Application No: CM/17/21/PL
Site Address: Land at Wren Cottage Horsemere Green Lane Climping BN17 5QZ
Description of works: Development of 2 No. 2-bed & 2 No. 3-bed detached dwellings & associated works (resubmission following CM/53/20/PL). This site is in CIL Zone 3 & is CIL Liable as new dwellings.

Thank you for your internet representation made on 15th July 2021 which has been recorded as an objection with the comments as follows:

PLOT 2 FLOOR PLANS
SCALE 1:100 @ a3

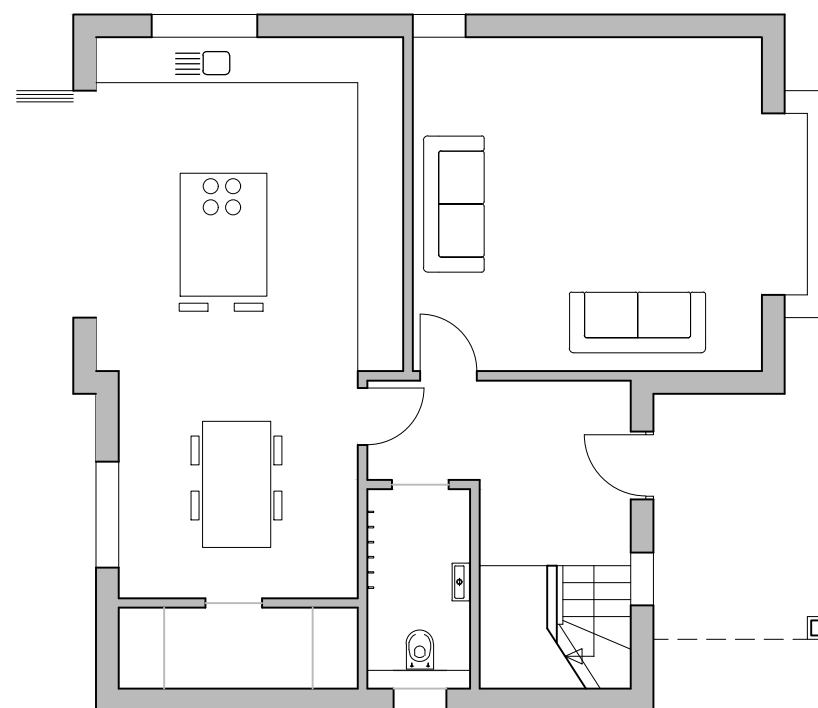
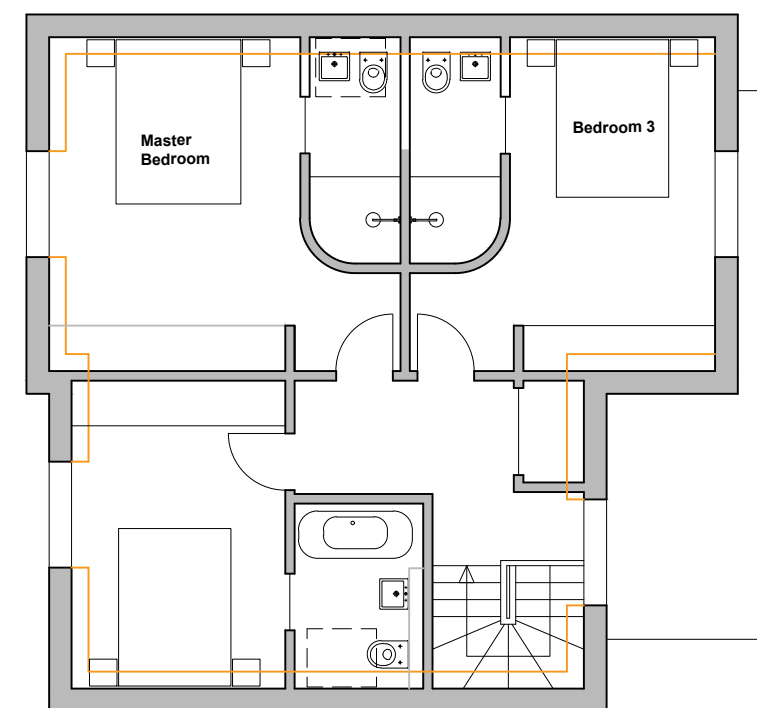
My original objections stand, in addition I object on the grounds that they have ignored the comment from Neil Crowther (Group Head of Planning) recommending removal of windows on the 1st floor rear elevations of plots 2 -4:

I will be recommending refusal of the proposals as they currently stand. In order for a scheme to be considered favourably, I would suggest that Plots 2 - 4 are proposed without first floor windows to the rear and are significantly reduced in scale so that they are 1 storey maximum height.
